Department of Primary Industries

OUT13/25058

27 AUG 2013

**Dargues Reef Gold Project Modification (10_0054 MOD 2)
Response to exhibition of Environmental Assessment**

Figure 3
APPROVED PROJECT SITE LAYOUT

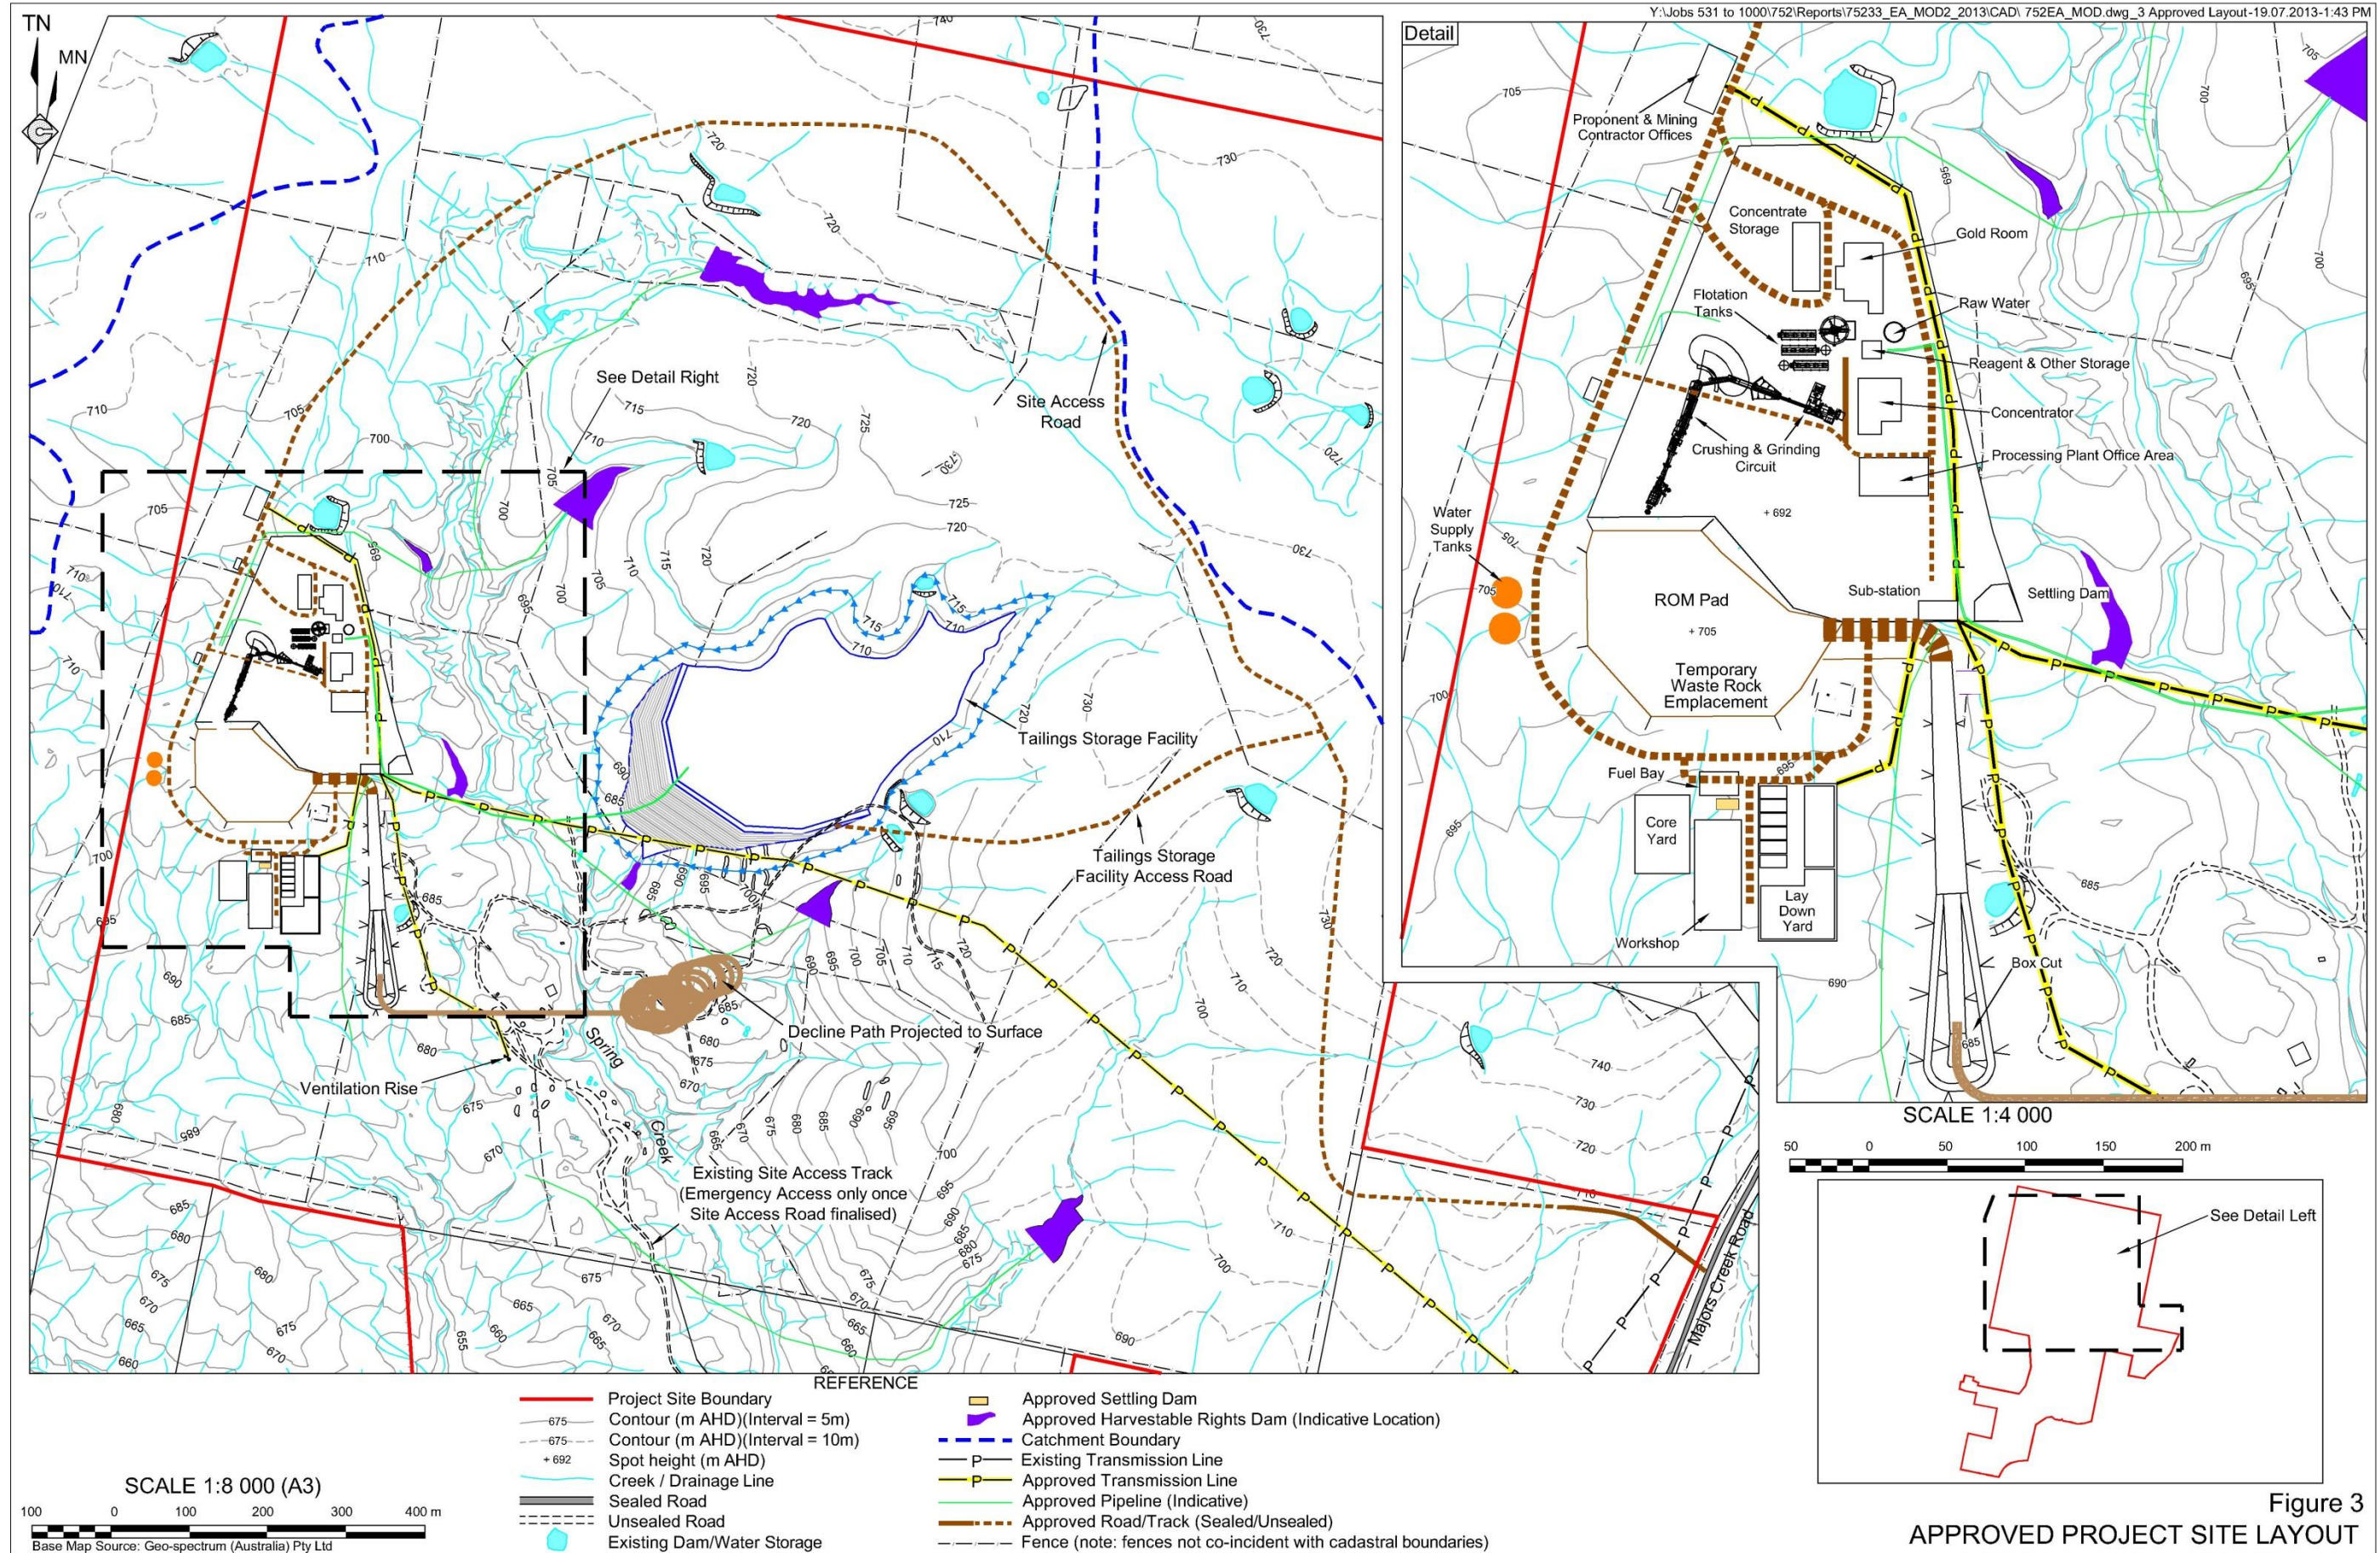
- (iii) It is noted the drainage layout in the Water Management Plan (January 2013) indicates a different design for the clean water diversion than the approved or proposed site layout in Figures 3 and 5 of the EA. It is expected this would be one of the revisions required to the Water Management Plan.
- (iv) The Office of Water requests a review of the Water Management Plan to address the proposed changes to the site layout and disturbance area.
- (v) Should the modification application be approved the following condition is recommended:
 - The Proponent shall review the Water Management Plan for the project. This Plan must be developed in consultation with the Office of Water and include:
 - (a) details of water use, storage, monitoring and management on site,
 - (b) detailed plans of water management on site, and
 - (c) a Sediment and Erosion Control Plan.

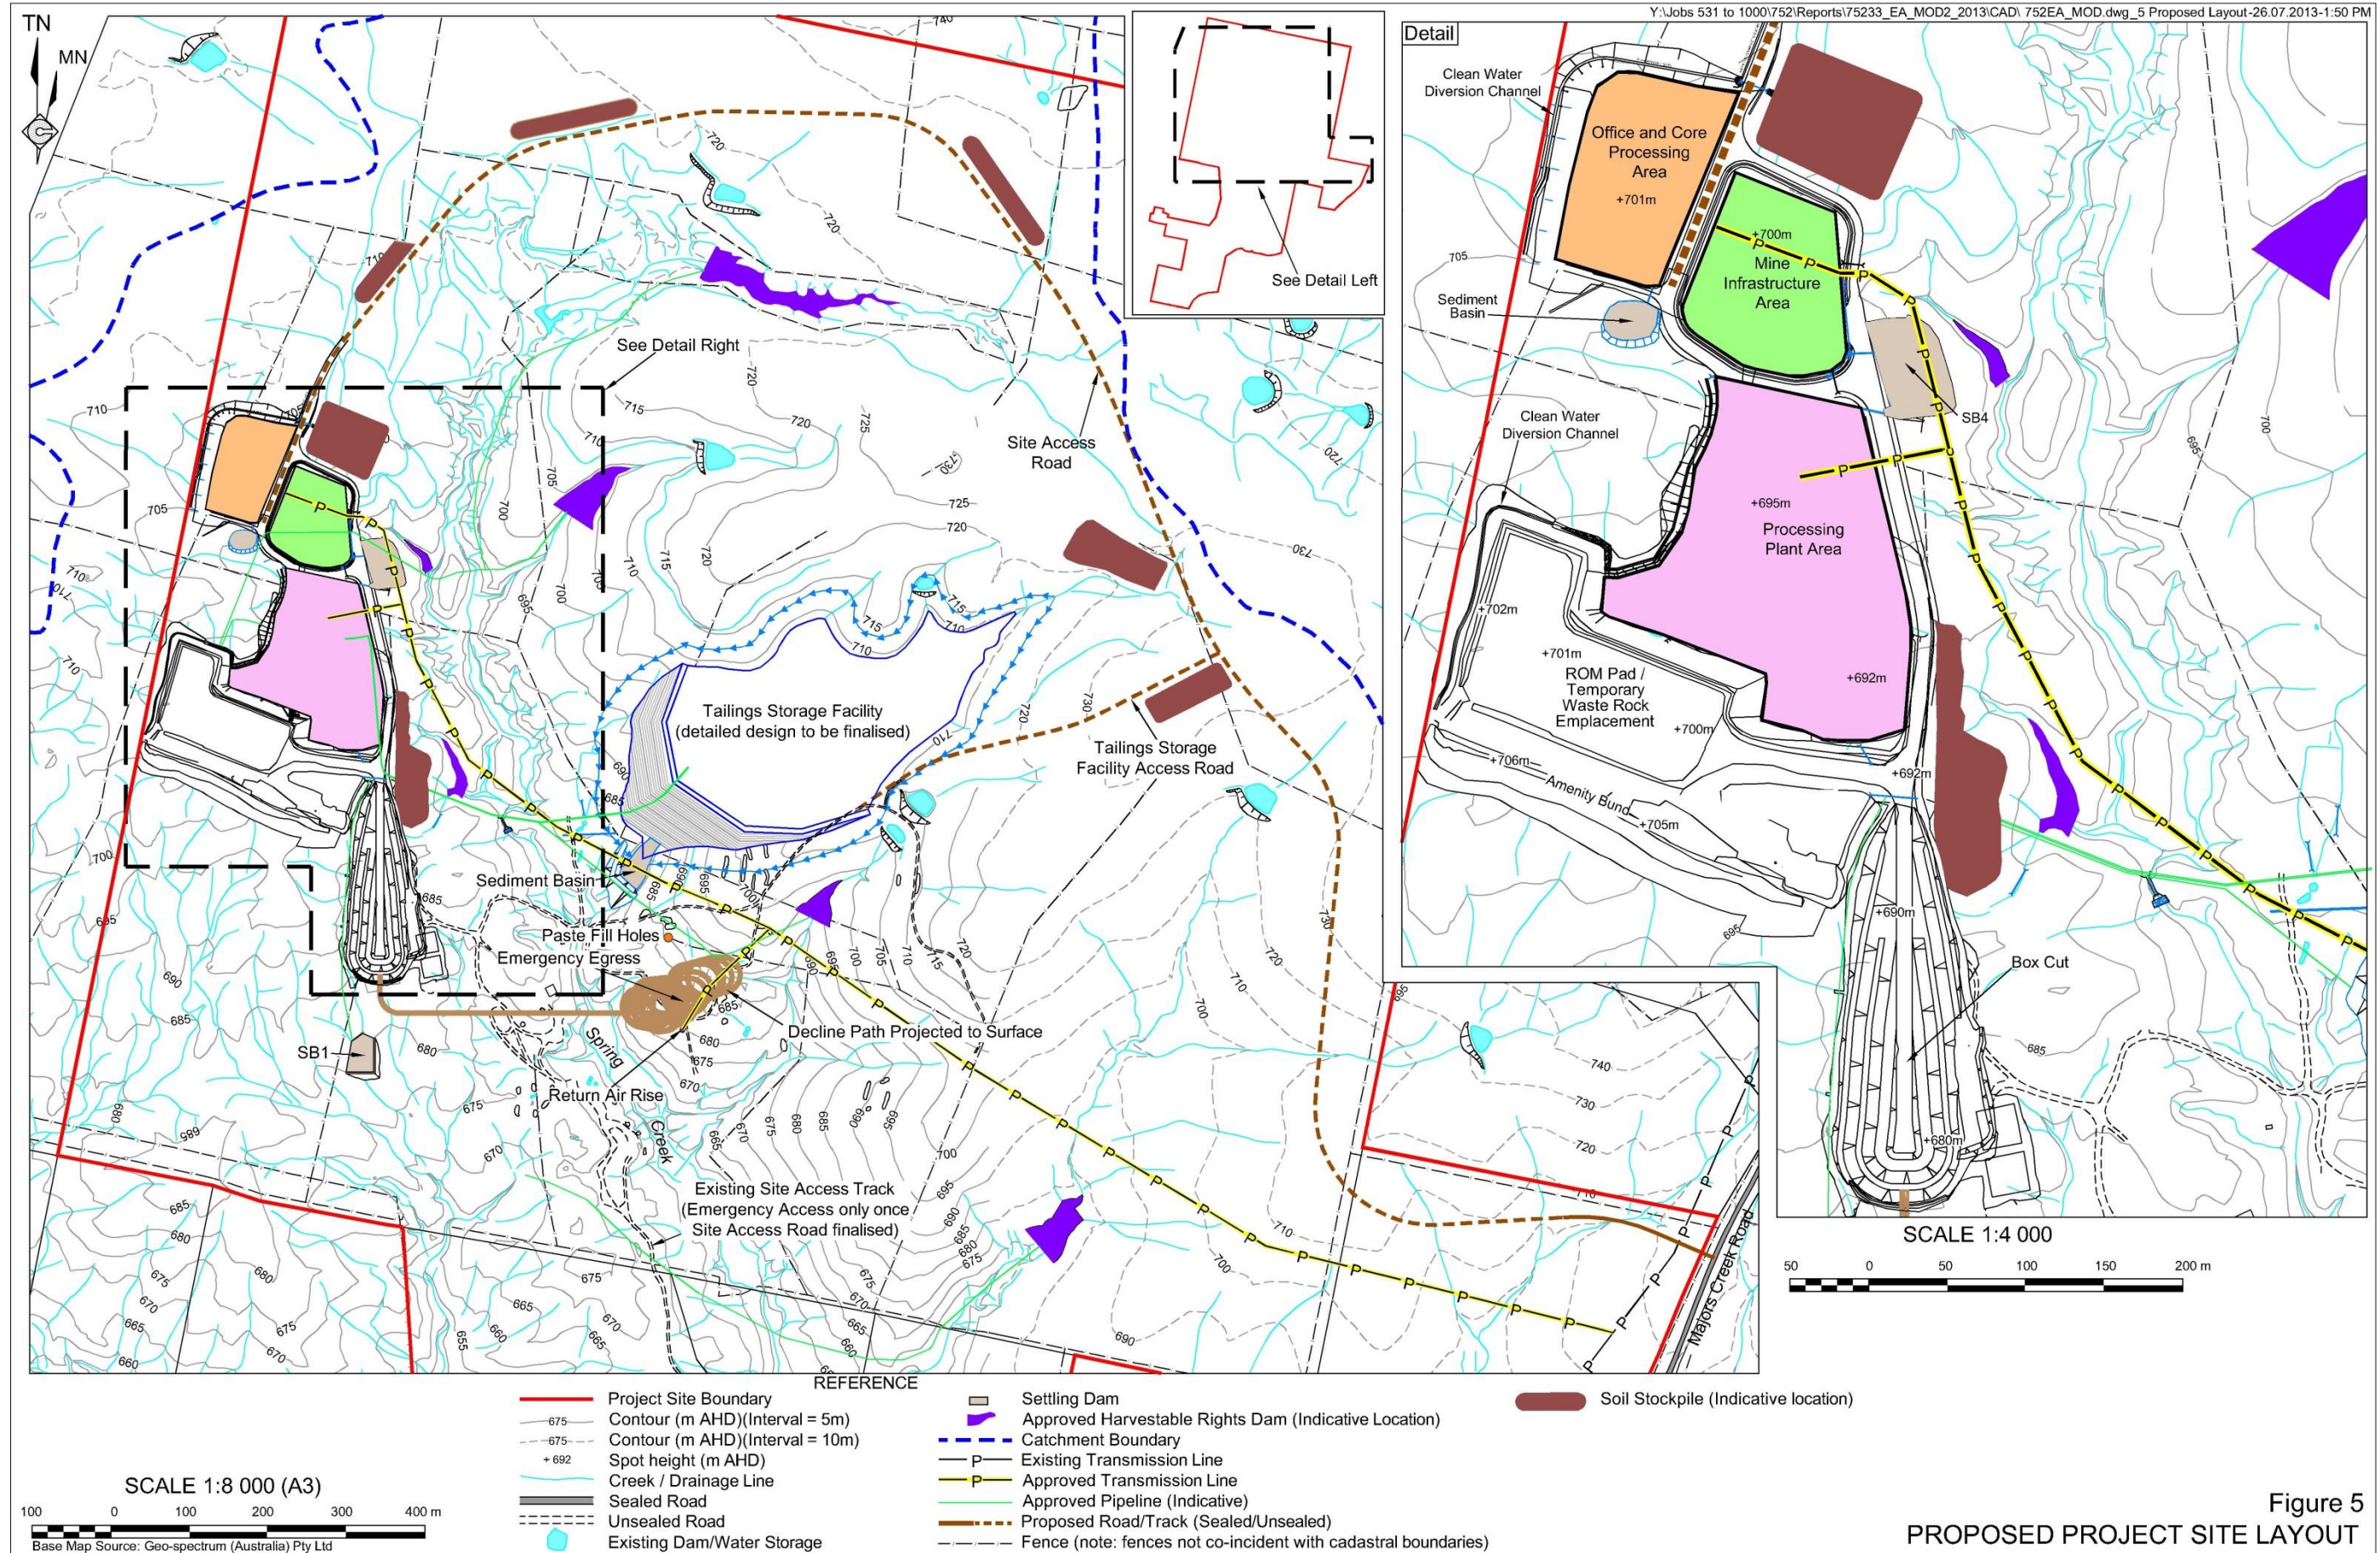
- (i) The modification proposal indicates the requirement to amend the surface water management system in terms of sediment basins and settlement dams. Clarification is requested as to the consistency of these amendments with the Maximum Harvestable Rights Dam Capacity. Of particular interest is the sediment basin at the base of the Tailing Storage Facility (TSF) which was previously the location of Dam F and is to capture water via the clean water diversion.
- (ii) Clarification is requested on the interaction of water collection between the sediment basin at the base of the TSF and the seepage collection pond. Figure 5 in the Environmental Assessment (EA) shows no distinction between the two

storages, hence uncertainty exists in the management of clean and contaminated water at this location.
